Application No: AL/31/22/PL
Site Address: Ryefields Farmhouse Oak Tree Lane Woodgate PO20 3GU
Description of works: Demolition of existing building and erection of 4 no. houses with associated access, landscaping, parking and associated works. This site falls within Strategic Site SD5, CIL Zone 1 (zero rated).

Thank you for your internet representation made on 27th May 2022 which has been recorded as an objection with the comments as follows:

Figure 1.3: Proposed Site Layout

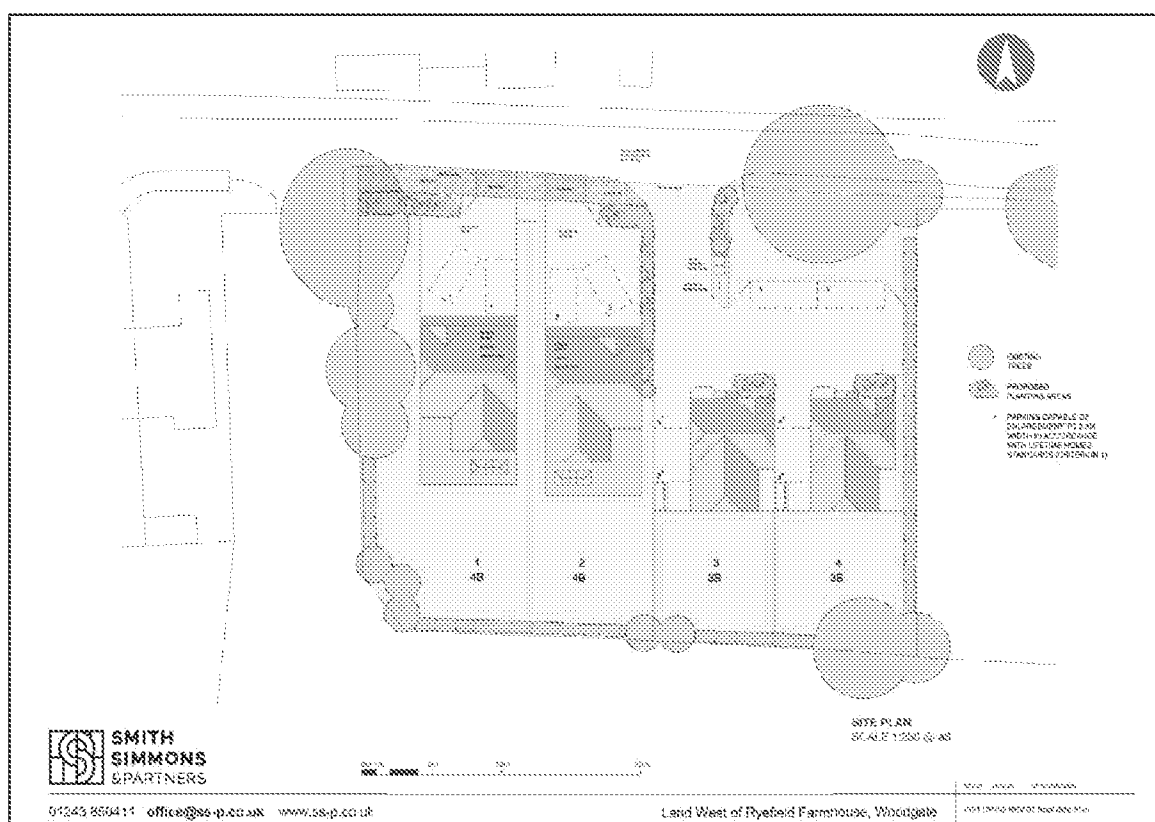
Item 1.14 of the Transport Technical Note talks about a 2m wide footway along the 'Western Edge' of the development. Surely the Developer means the 'Northern Edge'? Whatever, the Developer has yet again failed to explain how he intends to join his footway with the existing footpath of Oak Tree Lane. As explained in previous objection letters there is a 21m gap between the proposed development and the existing development of Oak Tree Lane. This 21m does not belong to the Developer. When it rains this area is entirely flooded and thus would prohibit access to the proposed development except by motor vehicle. The Developer has failed to address the points raised about foot traffic including access by the disabled.

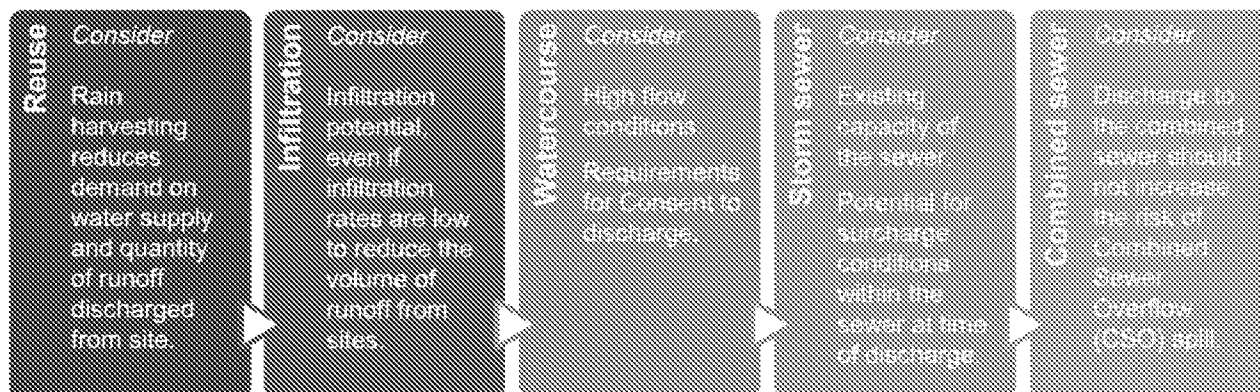
In the report submitted by the Developer regarding both Foul and Surface water the Developer states both will drain "by gravity to the adjacent 180-unit Woodgate site". The 180 unit Woodgate site is yet to receive planning permission. How can the Developer claim to be utilising a site which currently does not exist?
